RODWAY PLANNING
CONSULTANCY LIMITED

17th February 2022

**Section 96A Application for Non-Material Minor Amendments (NMA) to Planning Permission
WA/39/18/PL
New dwelling adjacent to No.48 The Meadows, Walberton, West Sussex BN18 0PB**

Drawing No Status Revision
181260/ 02 A

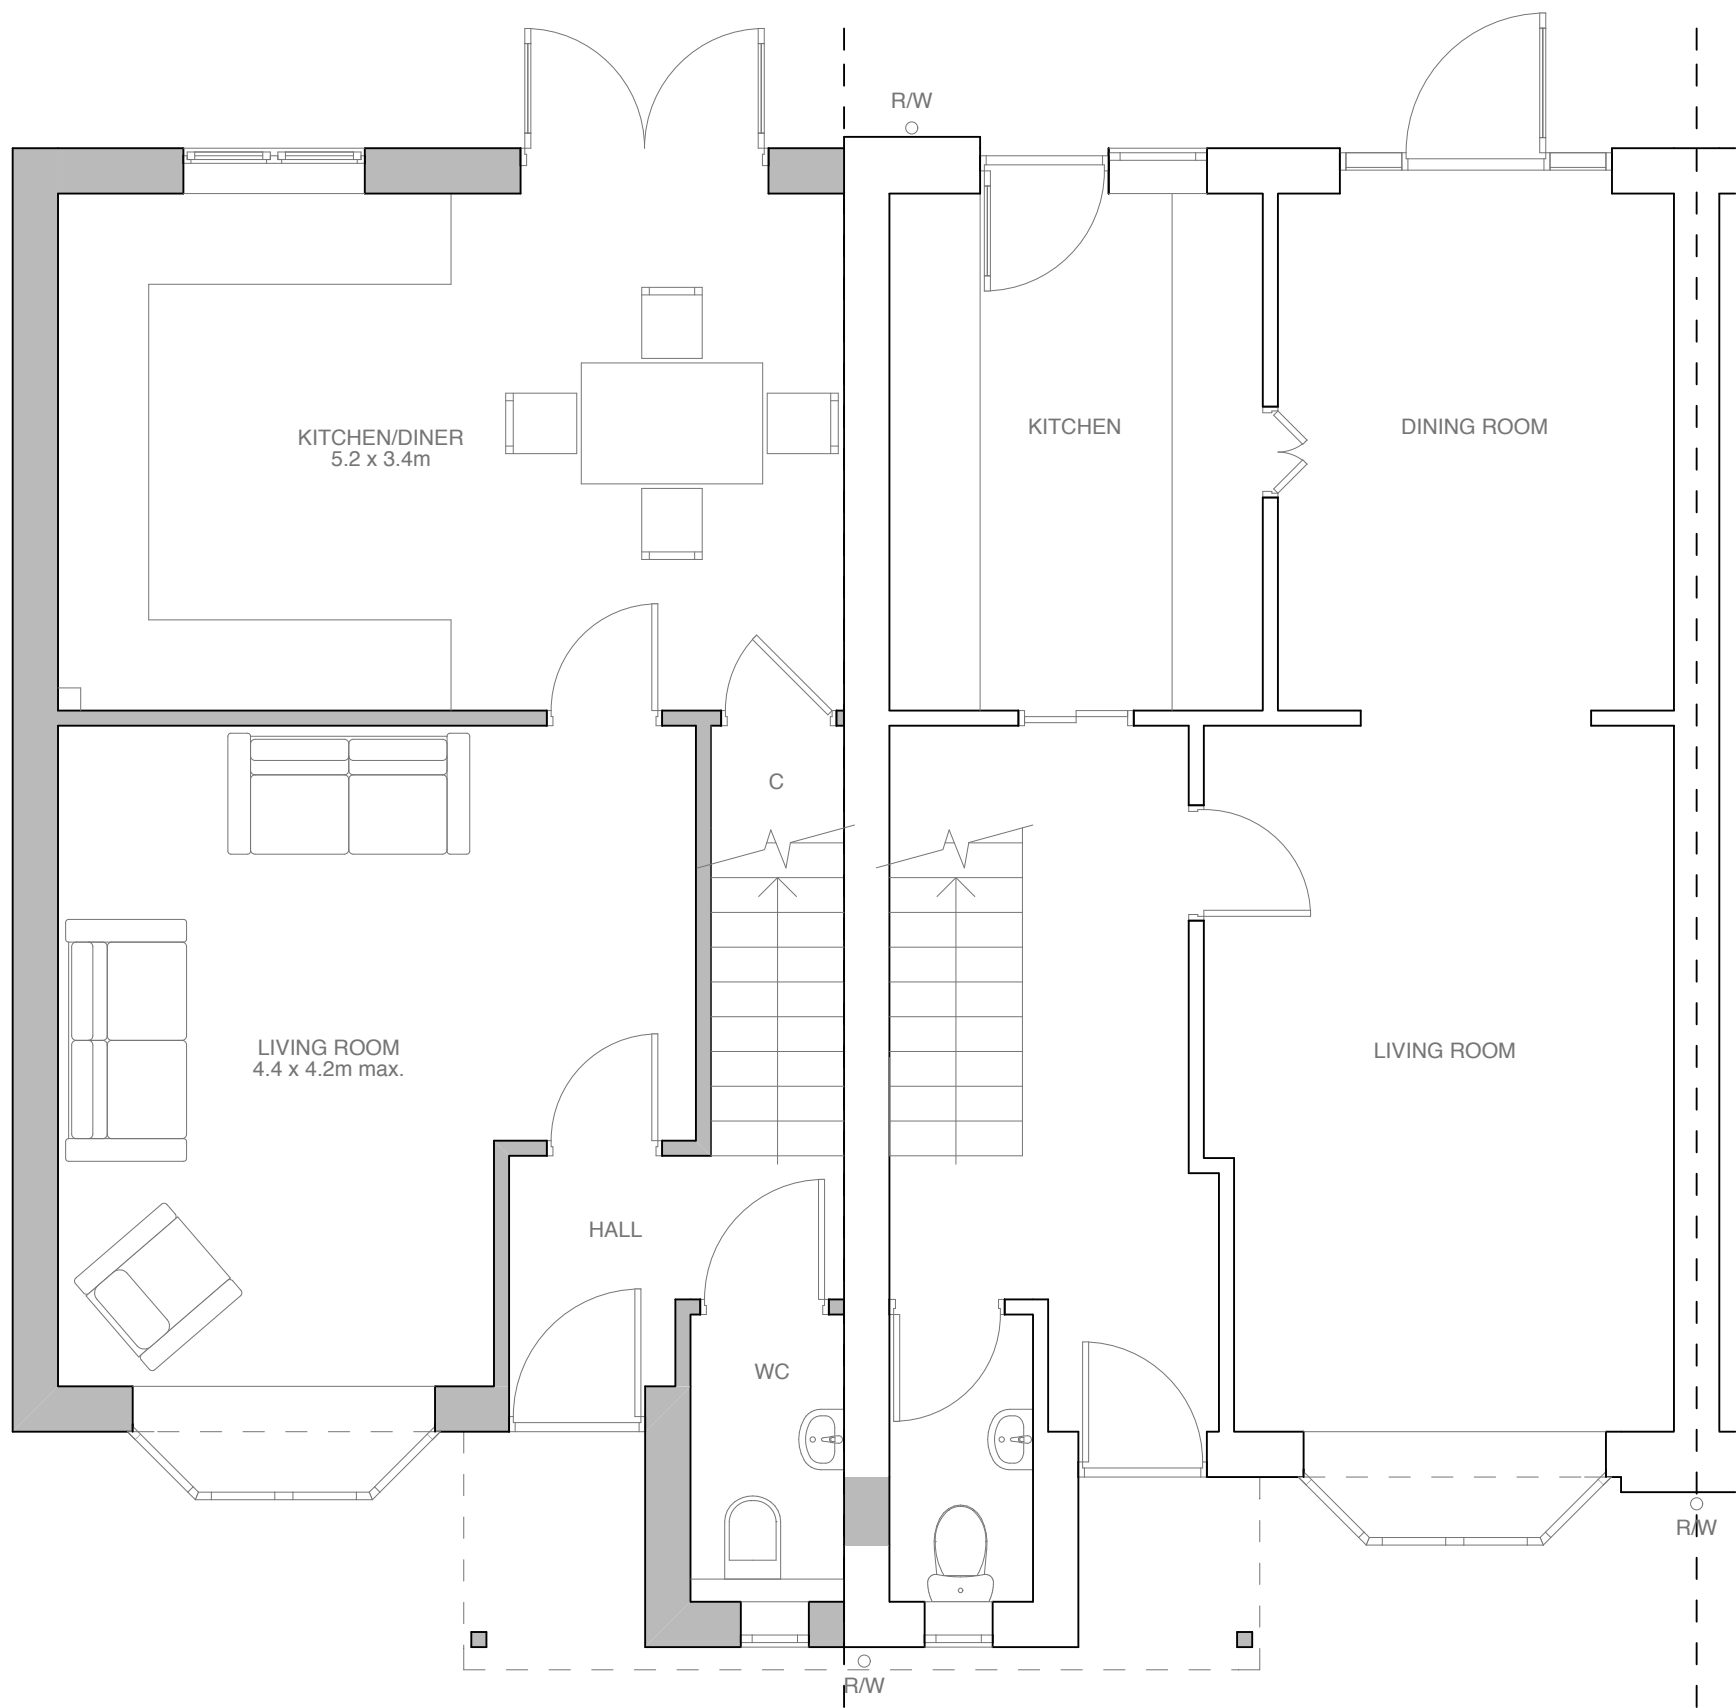
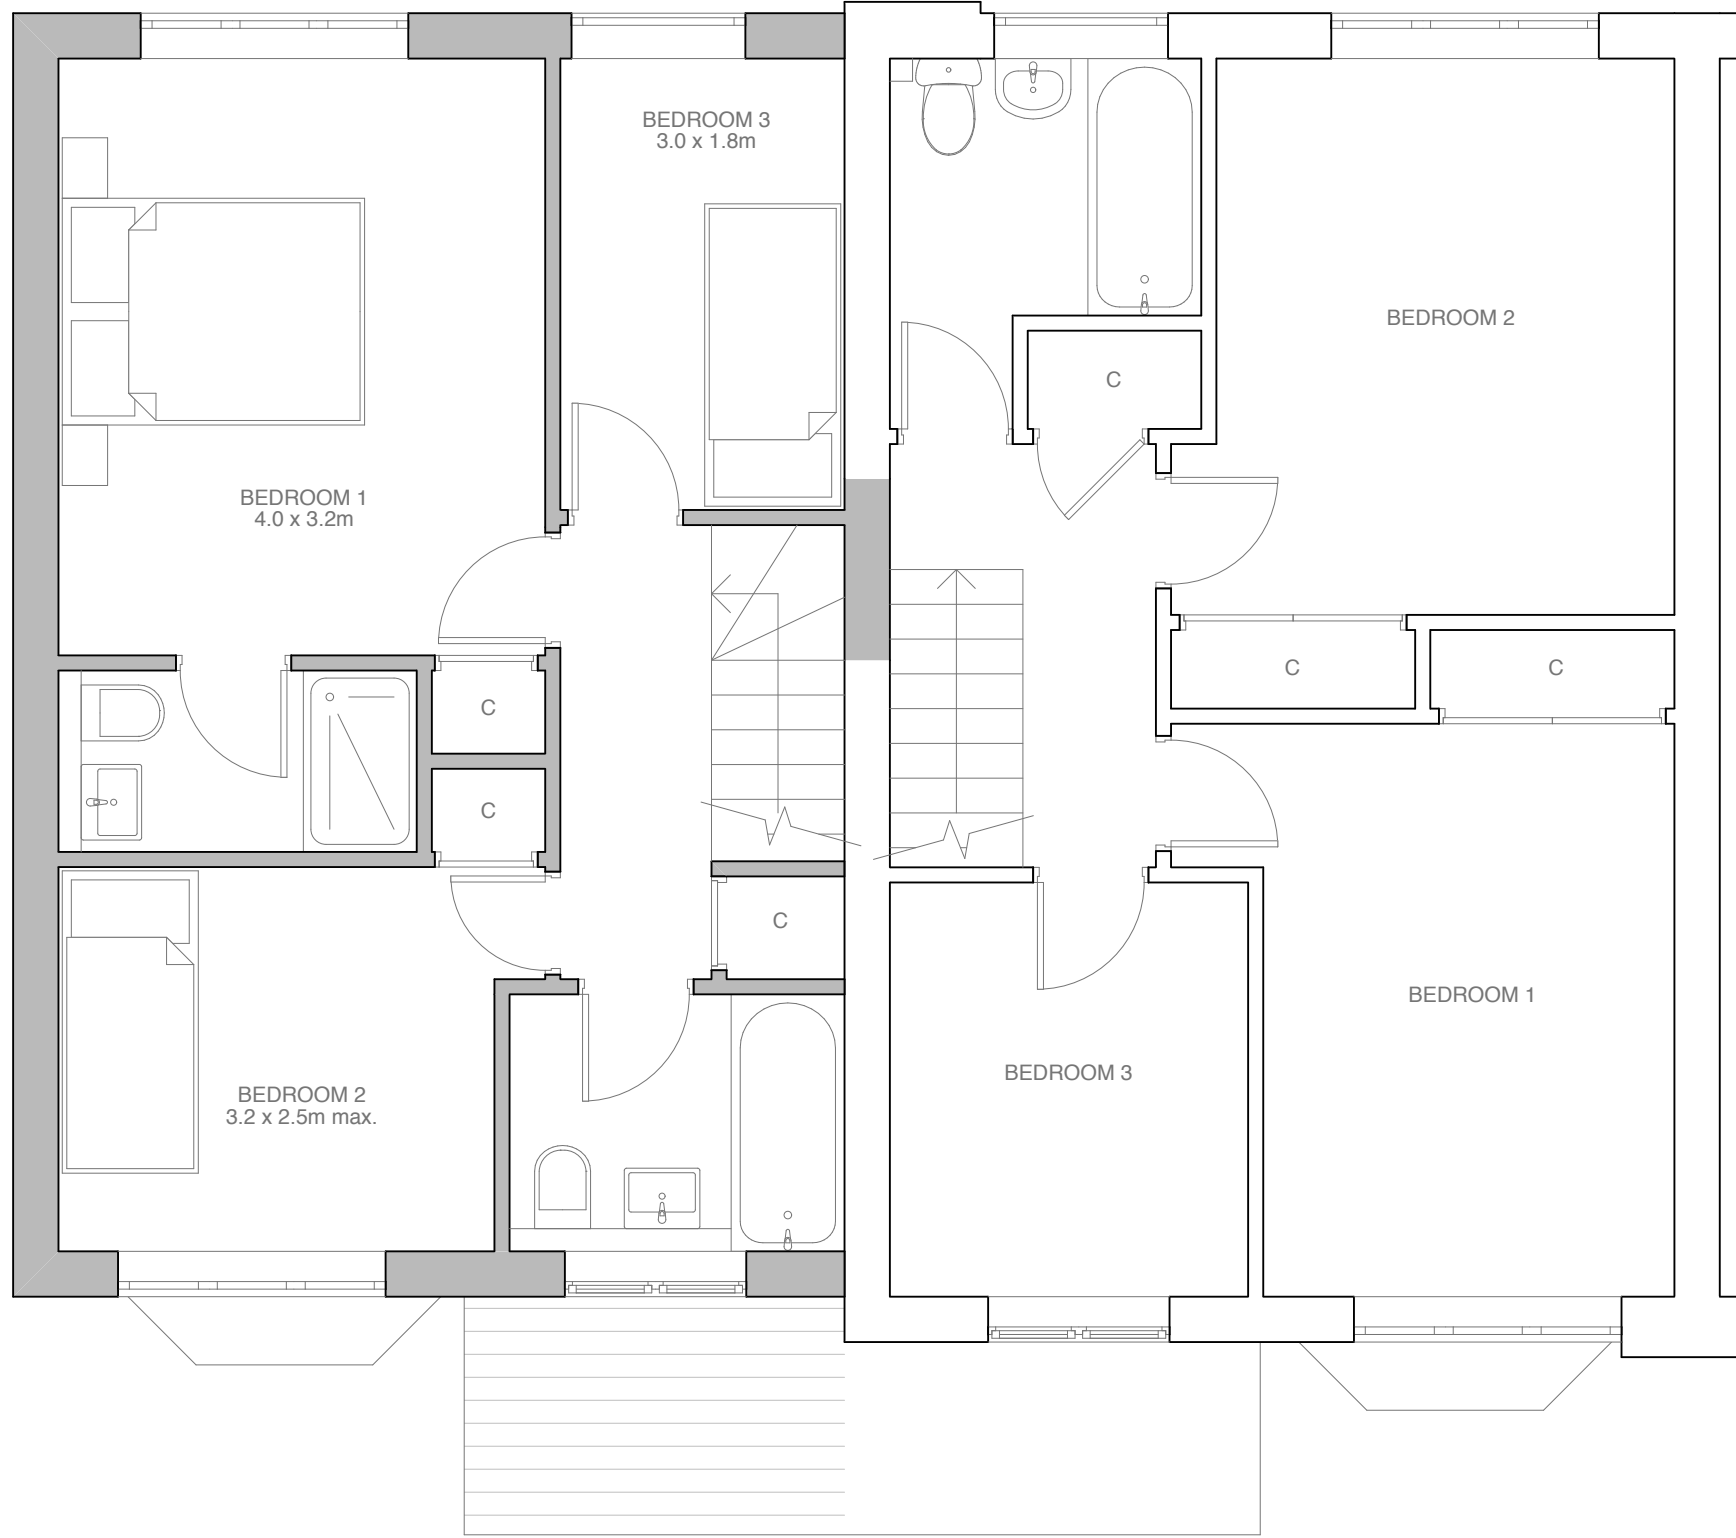
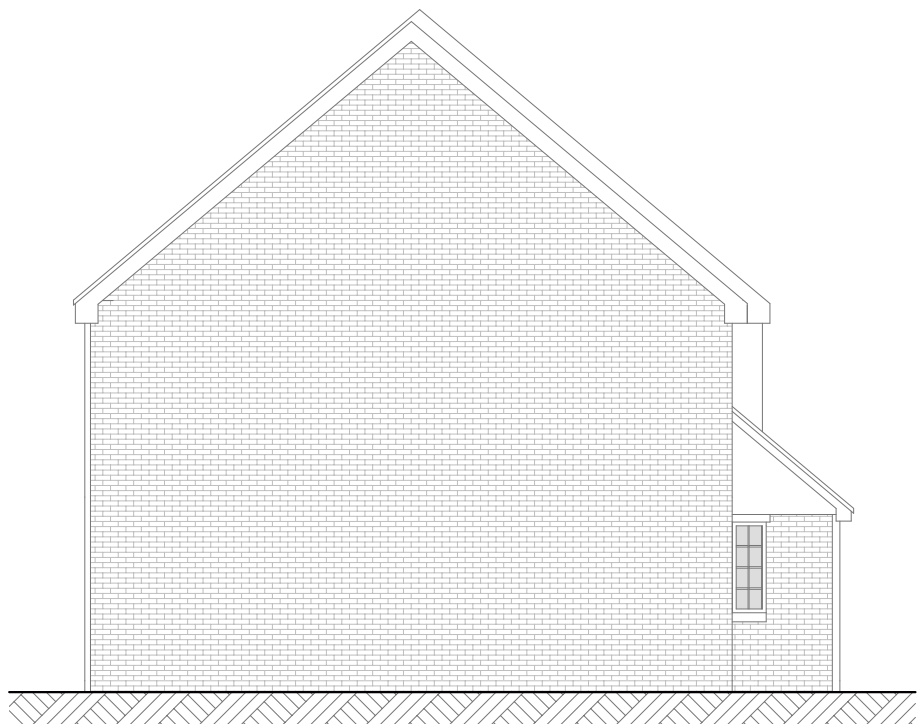
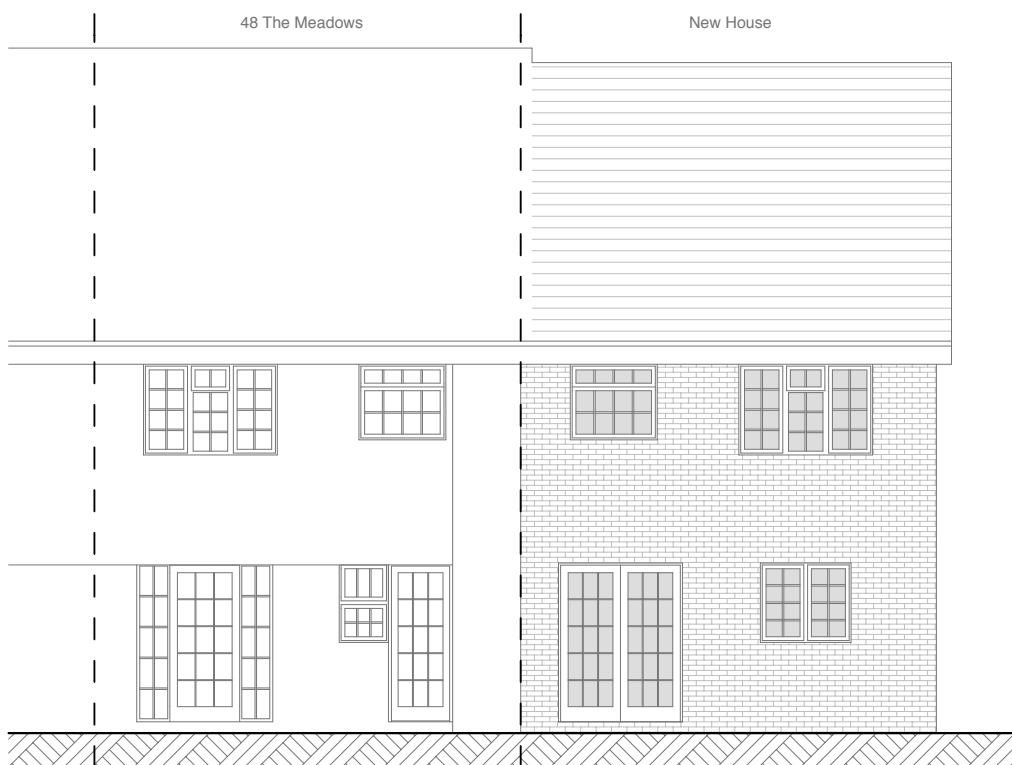
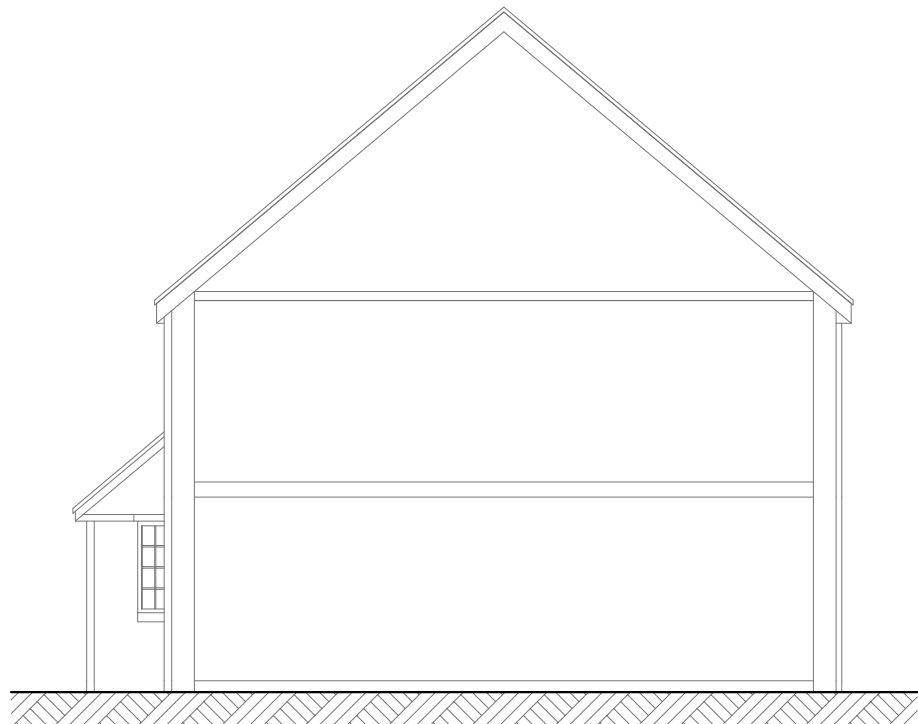
Essentially during his consideration of Planning Application WA/39/18/PL, Mr Wood requested revisions to the originally submitted drawings so as to provide an enlarged space for car parking to

the front of the site. The result was that the front elevation of the new dwelling is set back by 300mm, and the ridge line of the roof is also slightly reduced as a consequence. This is detailed on the following drawings:

- 181260/ 02 Revision A 'Proposed Plans and Elevations'
- 181260/03 Revision B 'Location & Block Plans'
